Ann Machado - 65 Pine Street - Permit #2013-01601 - legalization of nonconforming dwelling unit

I have done the initial zoning review for the permit and at this point the application is incomplete. You have provided evidence that the basement unit has been there since before April 1, 1995 but how do we know this was the illegal unit? You need to provide evidence that there were six units in the building since before April 1, 1995.

65 PINE STREET - BASEMENT FLOOR PLAN

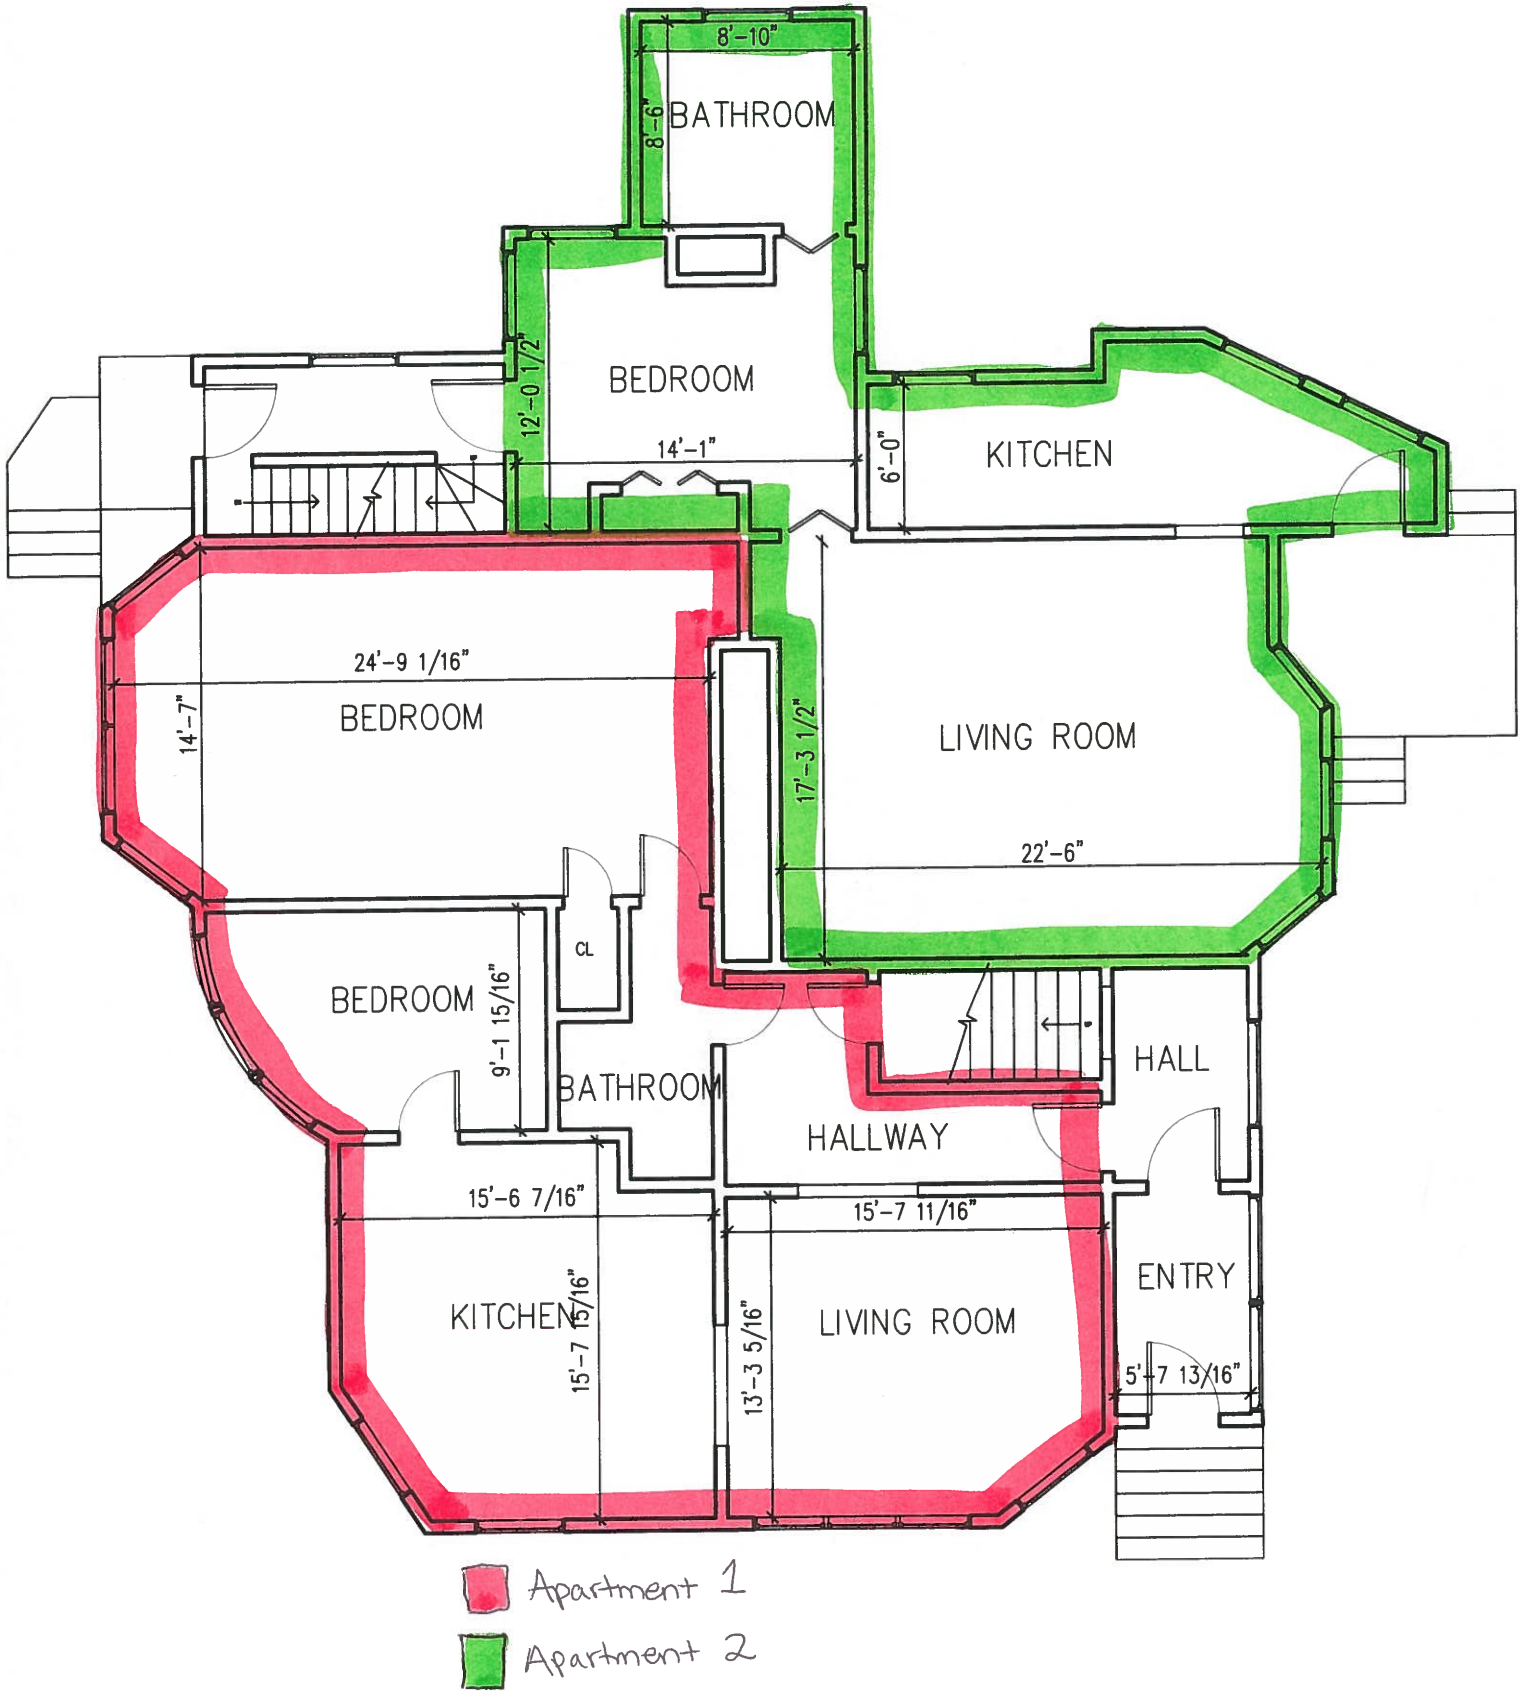
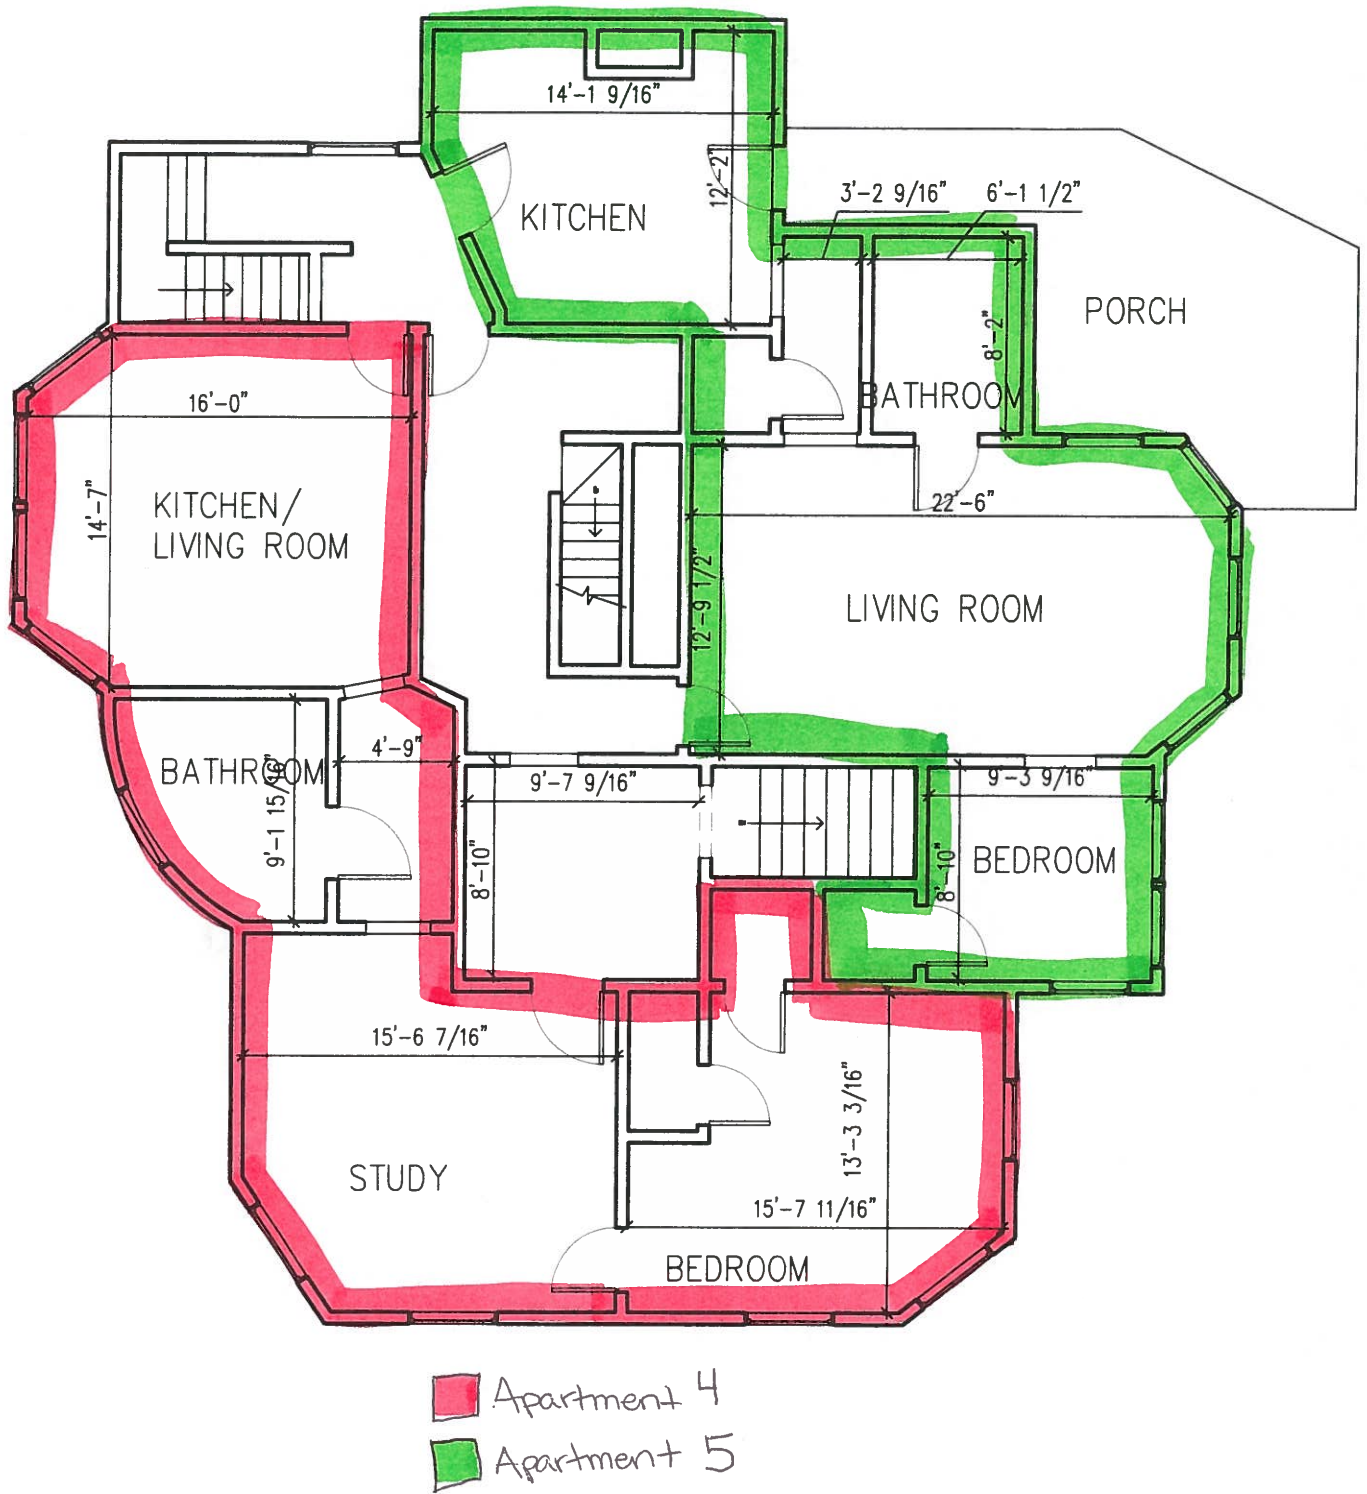
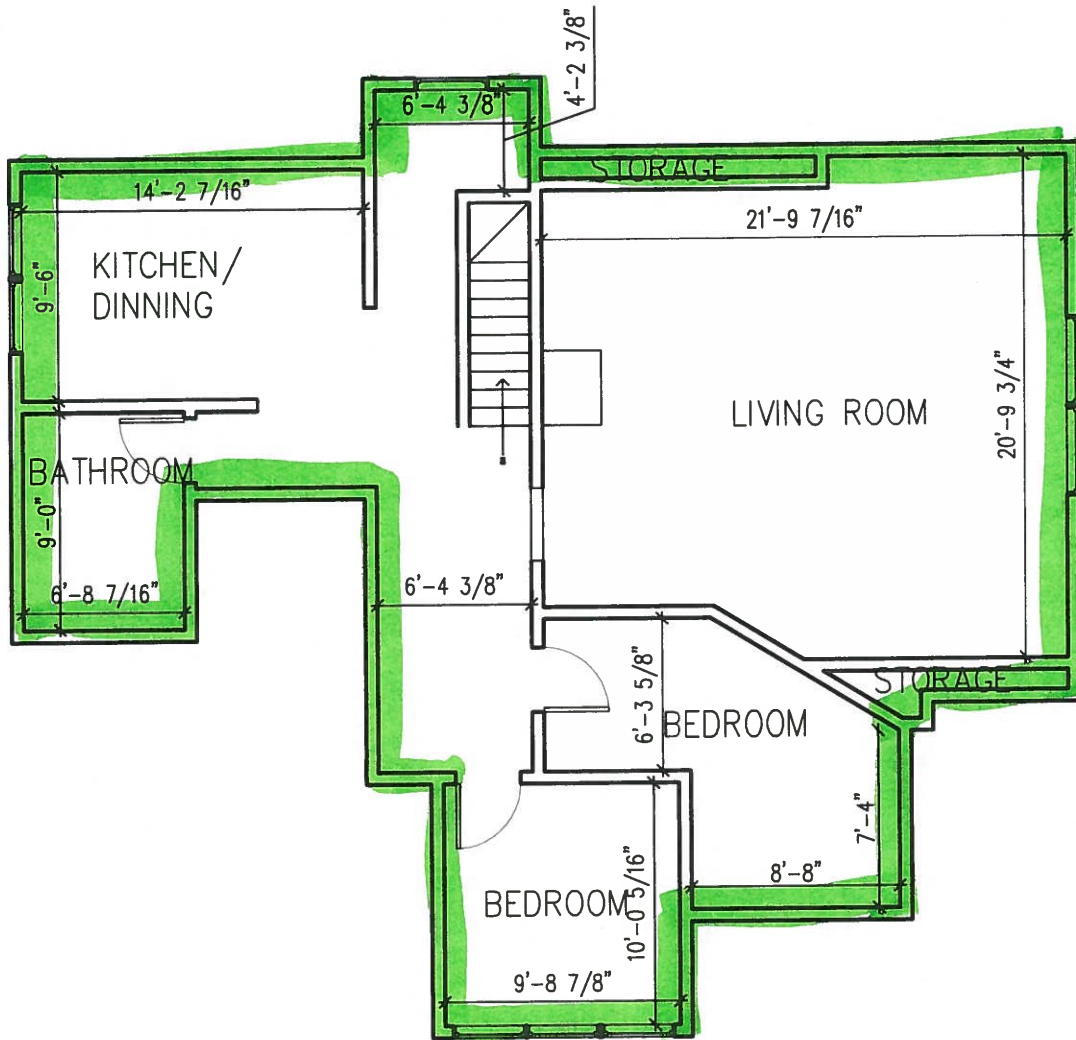
Second, you need to provide floor plans for all the units in the building not just the one unit that you consider to be the illegal one.
